**YOUR REF: - TR010036**

**Application by Highways England for an Order Granting Development Consent for the A303 Sparkford to Ilchester Dualling  
Submission made by Somerset County Council pursuant to Deadline 1 of the Examination Timetable**

**Planning Inspectorate Reference TR010036**  
**Deadline 1 submission – 11<sup>th</sup> January 2018**  
**Summary of Relevant Representation from Somerset County Council**

Appendix 1 APPROPRIATE MITIGATION FOR STOPPING UP OF TERMINUS OF BRIDLEWAY Y 30/28 (EASTMEAD LANE)

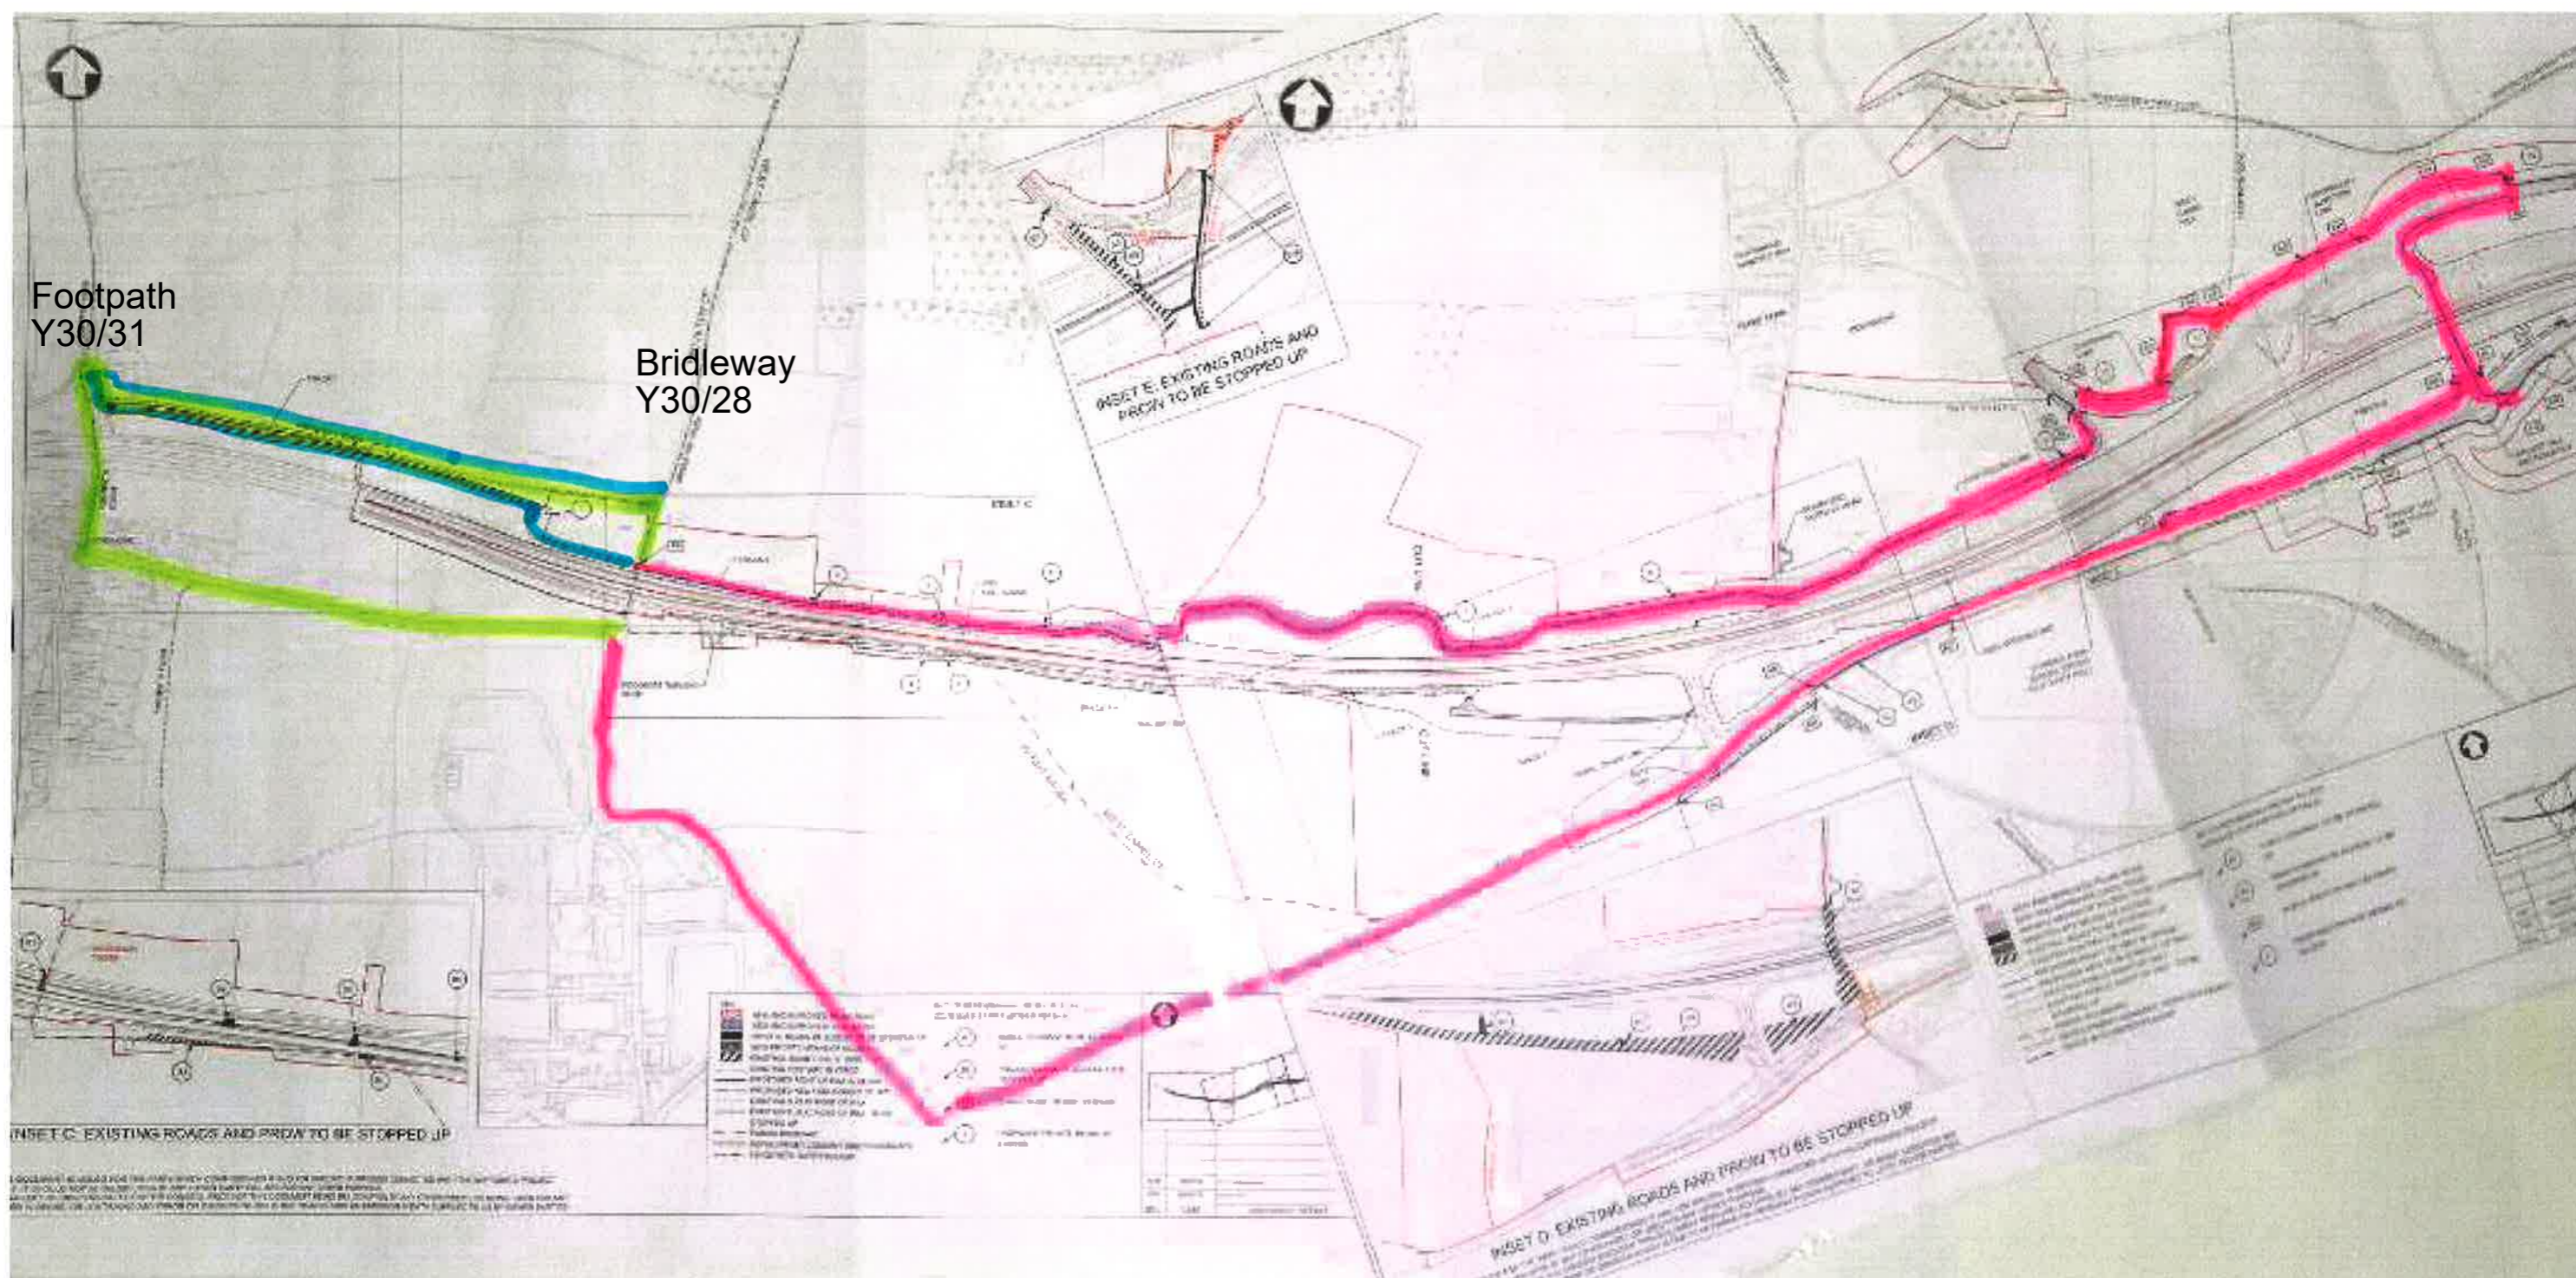
**Impact on Public Rights of Way:** SCC is concerned in respect of mitigation currently proposed by Highways England for the impact of the stopping up of the connection of Y30/28 with the A303. SCC has an alternative mitigation proposal which is more convenient and shorter in length for affected users.

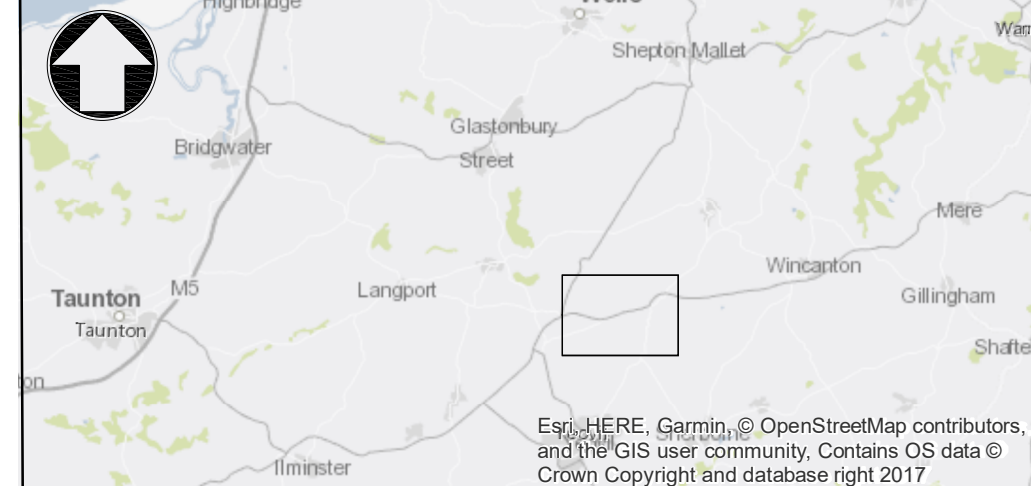
The Local Impact Area defined in the Environmental Statement does not appear to include the locations of West Camel, Queen Camel or Podimore Roundabout therefore it appears that a significant amount of scheme impact has not be included within the report which would enable assessment of effects linked to noise and air quality. Consideration of this is therefore required when establishing whether mitigation measures would be necessary.
